KIRKLEES METROPOLITAN COUNCIL INVESTMENT & REGENERATION SERVICE

DELEGATED DECISION TO DETERMINE PLANNING APPLICATIONS

Reference No:	2024/62/90091/W
Site Address:	20, Upper Bank End Road, Holmfirth, HD9 1EW
Description:	Erection of single storey extension to side and rear with raised terrace and balustrade
Recommending Officer:	Joanna Rednall

HOUSEHOLDER DELEGATED REPORT

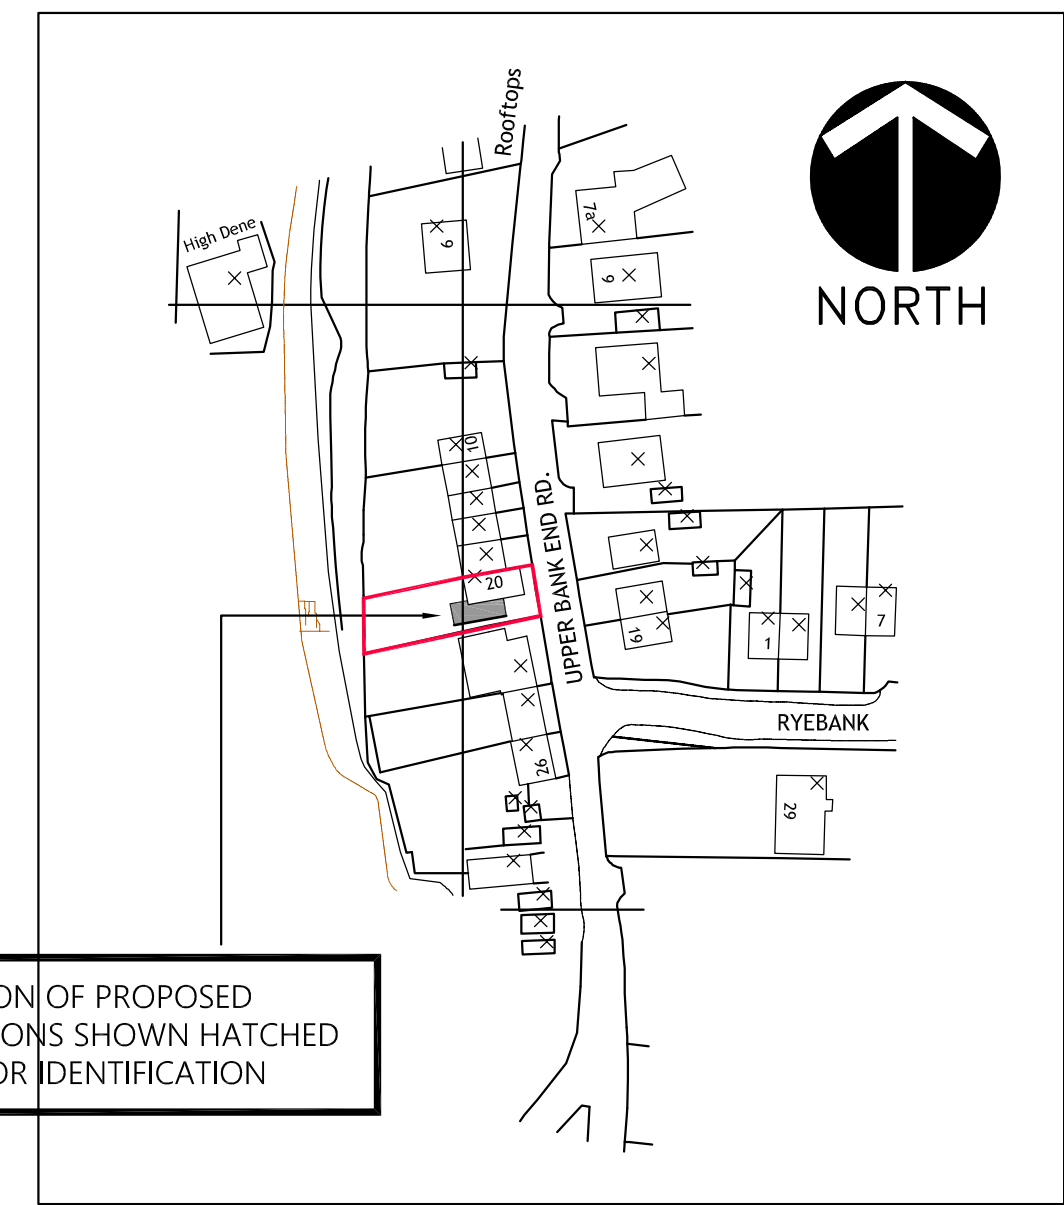
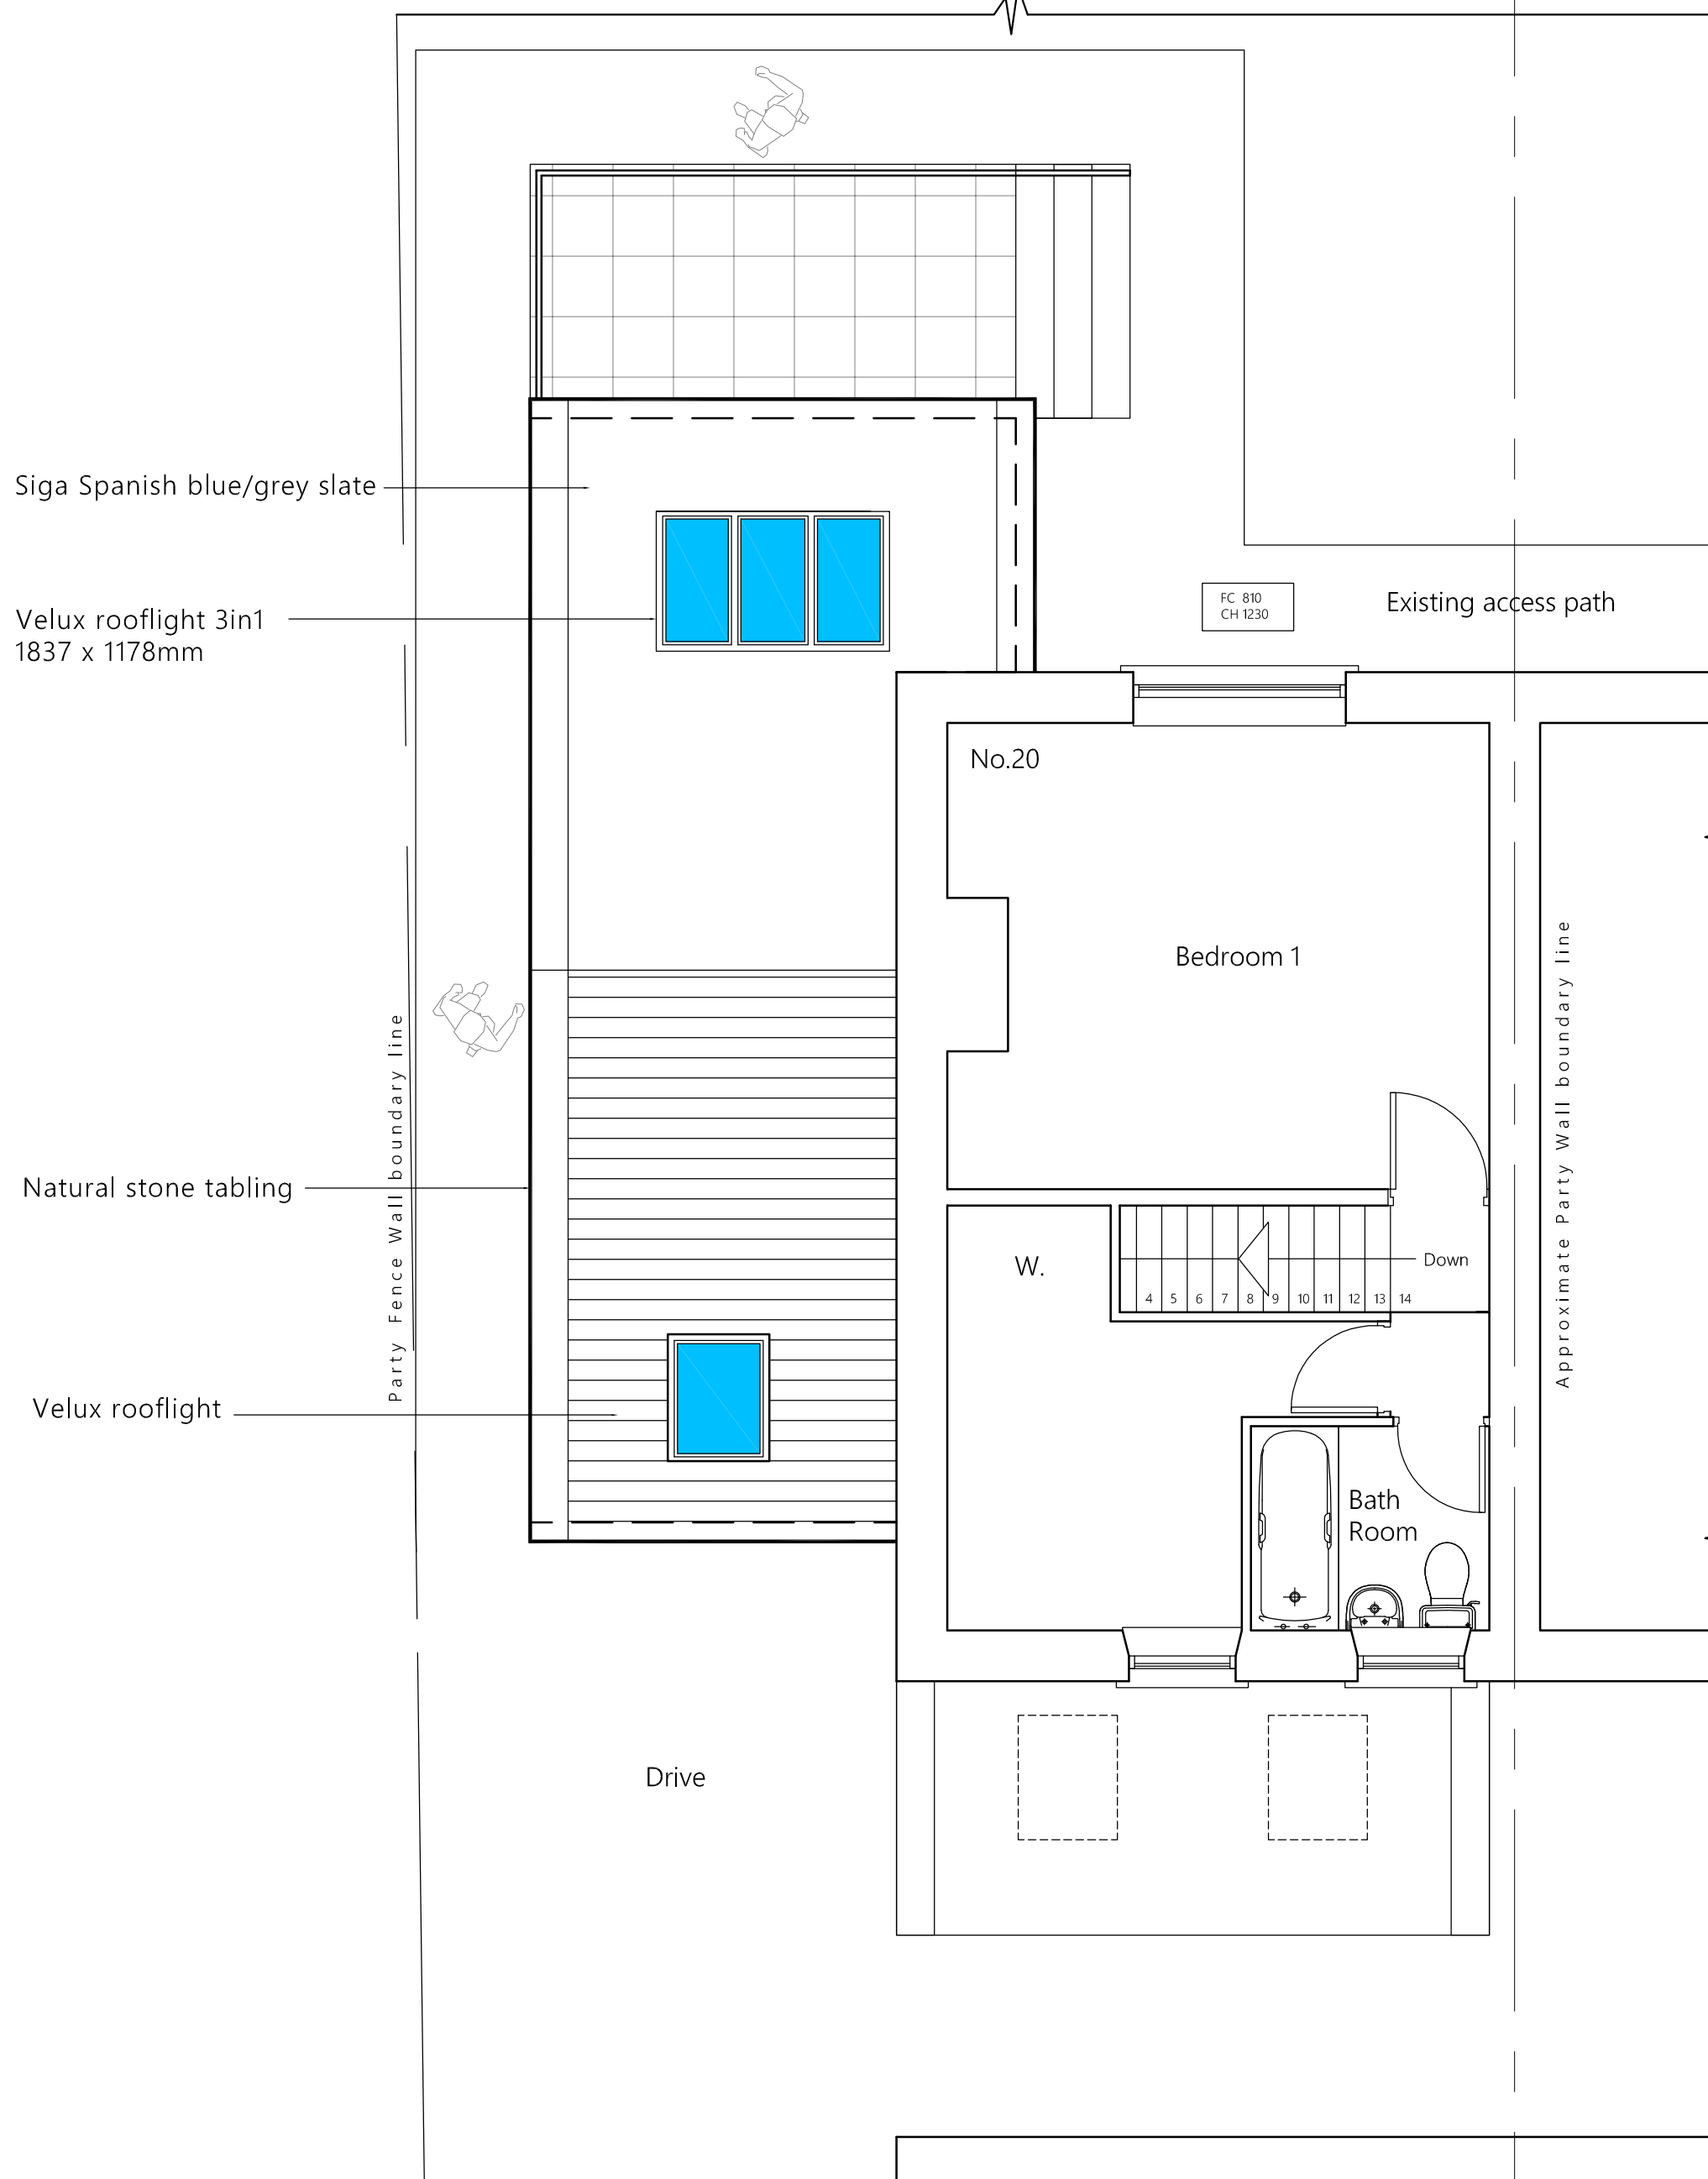
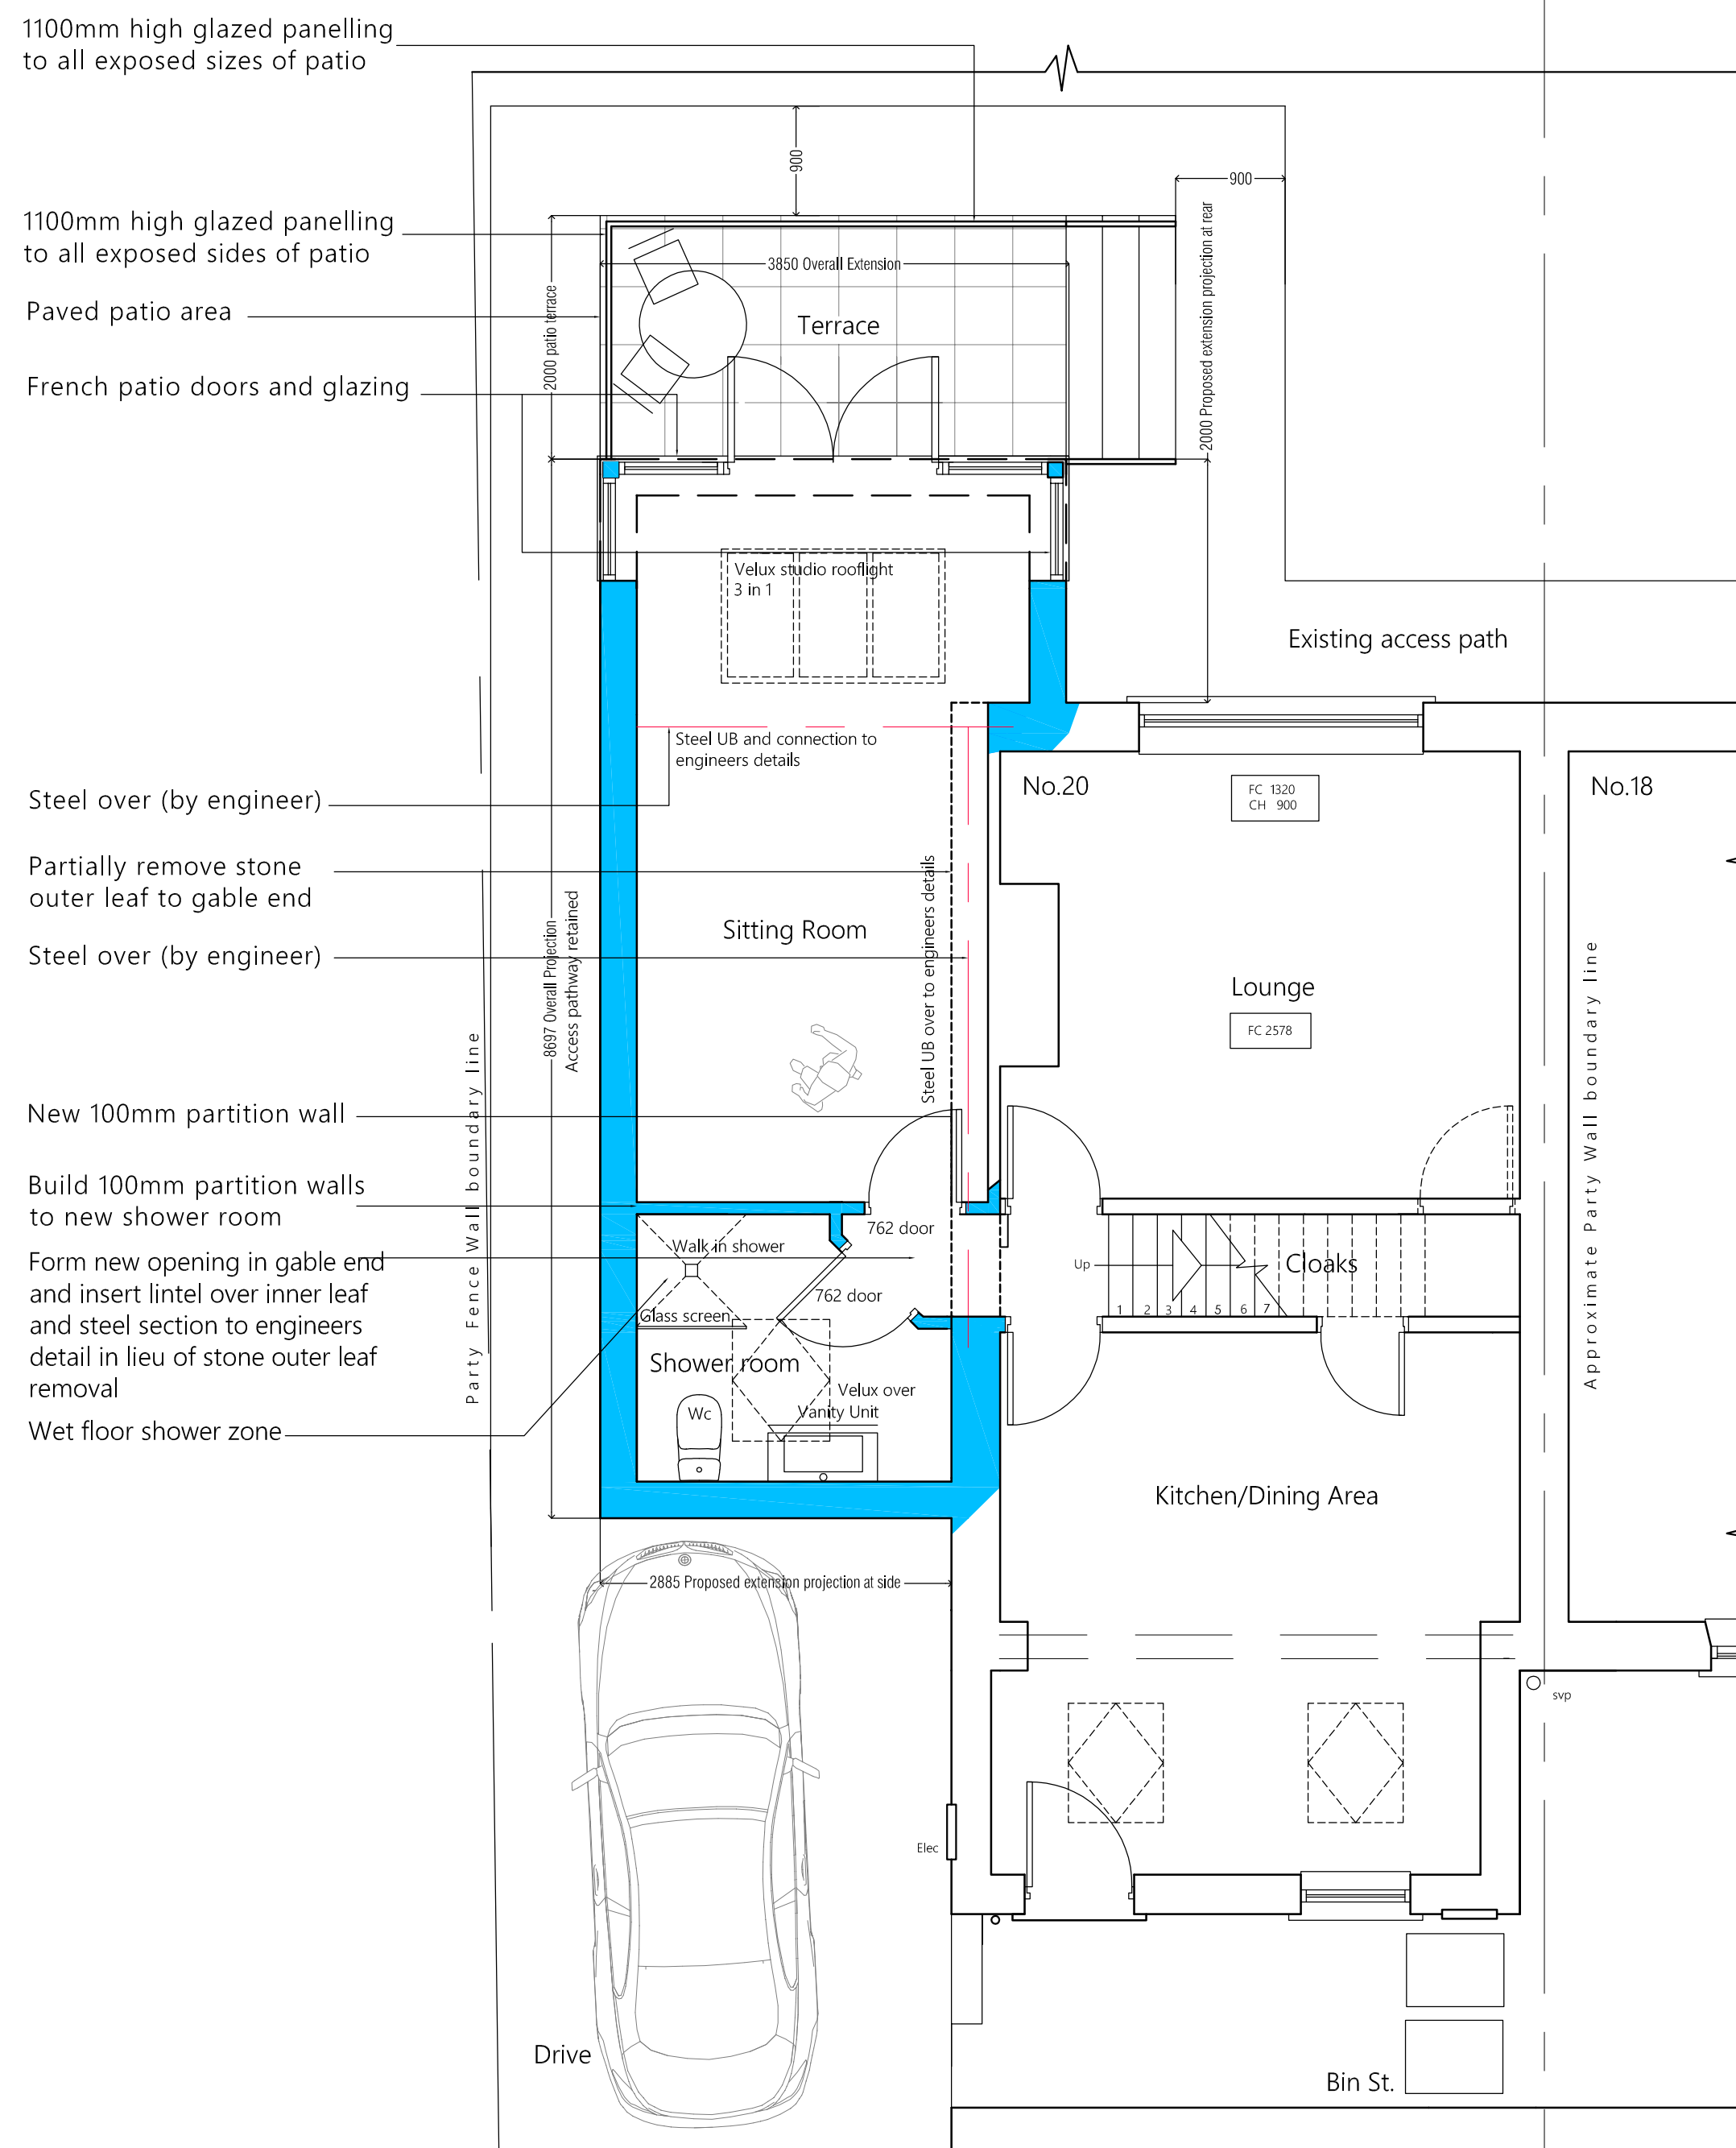
The single storey side extension would project ~2.8 metres from the south-facing elevation and extend ~6.7 metres along the side elevation of the application property. The eaves height would be ~2.6 metres with a total height of ~5.8 metres to the ridge of the gable roof. The side extension would be set back ~3.2 metres from the front elevation of 20 Upper Bank End Road and the front (east-facing elevation) roof slope of the extension would host one velux rooflight.

Within the rear (west facing) elevation of the extension would be French patio doors with one long glazed window either side of the patio doors, as well as an additional long window proposed within the side (south-facing) elevation of

The raised terrace would project ~2 metres from the rear elevation of the extension. It would have a width of ~3.8 metres and would be raised ~0.8 metres from external ground level with steps erected to allow access to and from the rear garden and rear extension. The proposed balustrade would be erected along the side and rear elevations of the terrace, and would have ~1.1 metre high glazed panelling to all exposed sides of the patio.

- *22, Upper Bank End Road – located to the south of the application site. The proposed extension would be set off the shared boundary by ~0.9 metres with a proposed full-length window on the corner of the side/rear extension which has some potential to overlook part of the rear amenity space at No.22, given that the extension would be elevated by ~0.8 metres. To prevent any detrimental impact on overlooking this window would be conditioned to be obscurely glazed, in addition a screen to this elevation of the raised terrace would be ensured by condition.*

Impact on privacy of neighbours (to sides, rear and front)	• KDP 3 & 4 of the SPD • Policy LP24 Design (d) (iv) • Policy 2 of the HVNDP • Chapter 12 of the NPPF	Window on side elevation to be conditioned as obscure glazed. Screening to be secured to the southern elevation of the terrace to prevent overlooking	✓
Impact on light and outlook of neighbours (to sides, rear and front)	• KDP 4, 5, 6 of the SPD • Policy LP24 Design (b) • Policy 2 of the HVNDP • Chapter 12 of the NPPF	Single storey in height with minimal rear projection would mitigate any detrimental impact on loss of light and outlook of neighbours.	✓
Remaining garden space of application property	• KDP 7 of the SPD • Policy LP24 Design (b) and (c) • Policy 2 of the HVNDP • Chapter 12 of the NPPF	Over half of rear garden space would be retained.	✓

4. The floor to ceiling height window serving the sitting room, in the southern side elevation of the extension hereby approved, shall be fitted with obscure glazing, minimum grade 4 before it is first occupied. Notwithstanding the provisions of section 55(2)(a)(ii) of the Town and Country Planning Act 1990 and the Town and Country Planning (General Permitted Development) Order 2015 (or any Order revoking or re-enacting that Order with or without modification) the said window shall thereafter be so retained obscure glazed.

5. Notwithstanding the plans submitted, the raised terrace shall not be brought into use until a 1.8 metre obscurely glazed screen (to a minimum privacy level of Grade 4 or equivalent) or timber fencing to a height of 1.8m high has been constructed to the southern elevation of the raised terrace. The obscure glazed screen or timber fencing shall thereafter be retained.
